April 13, 2015

**RE: Lot 24, Block 18, University Heights, 201 Princeton Drive SE
Grading and Drainage Plan
Engineer's Stamp Date 3-24-2015 (File: K16-D082)**

## GRADING AND DRAINAGE PLAN

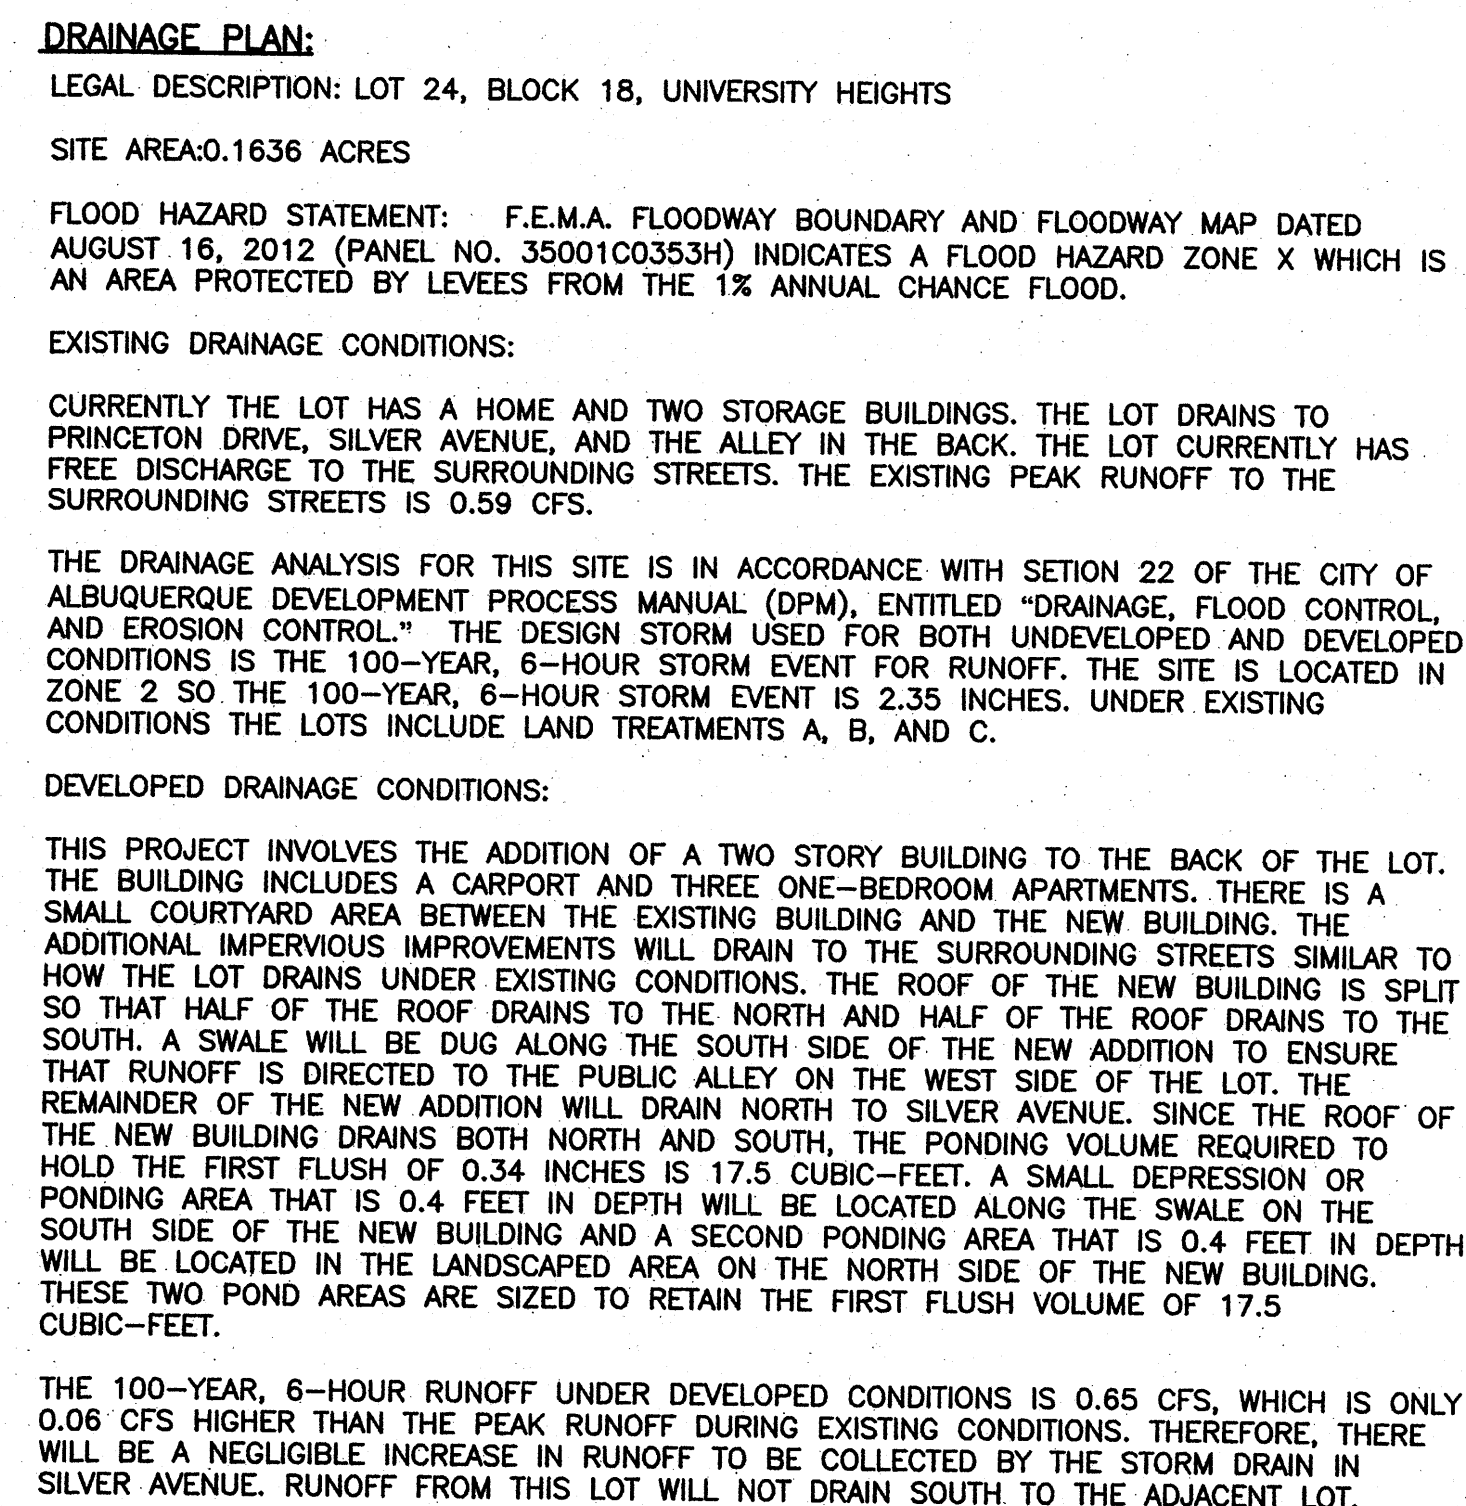
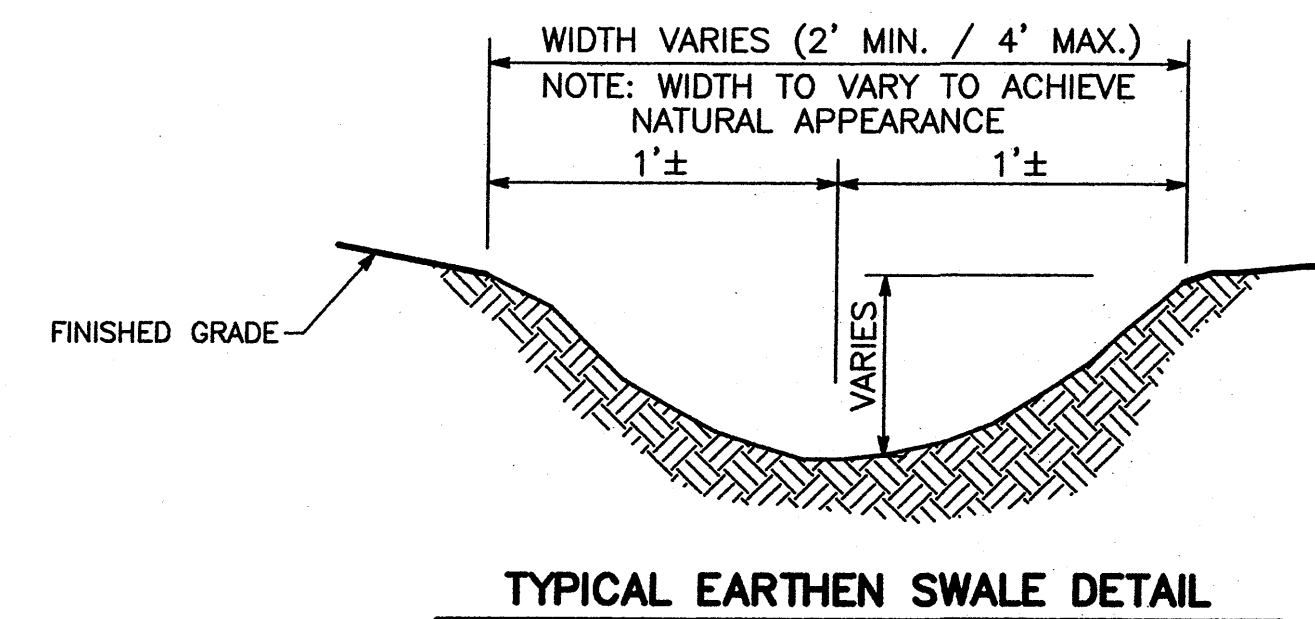
- 1) Label the area of the new building addition on the plan view, and label the existing building. Show property lines and actual basin boundary line on the plan view. Label the public alleyway.

- 2) As a result of the added impervious area, address first flush management as required per the COA Drainage Ordinance which is defined as 0.34" times the impervious area. Also, show all roof drains for the new building. It looks like there is opportunity to retain first flush volumes either immediately north of the new building or south of the building within the proposed swale. Show first flush computations.

- 3) For the 100-year hydrologic calculations, label "Existing Total Runoff" and "Proposed Total Runoff". Also, within the legend, show legend for new concrete, existing building, new building, and existing spot elevations.

- 4) In the discussion for Developed Drainage Conditions, address the site's ultimate discharge into the storm drain in Silver Avenue.
- 5) Provide a detail for the swale along the south side of the new building and its connection to the public alleyway and/or Princeton Drive, and provide more spot elevations for this swale. Show all existing curb as applicable in these areas. In the discussion for developed drainage conditions, address any impact of on-site drainage to the property south of the new development. If some of the on-site drainage is discharged to Princeton Drive, address this in the write-up.

- 6) Provide width of public alleyway on the plan. Include more detail for the proposed driveway, including calling out a width and applicable COA standard drawing details. Showing a top of curb elevation for the new driveway seems to conflict with the driveway location unless this top of curb also represents the flowline. Label the location where new curb ties to existing curb.
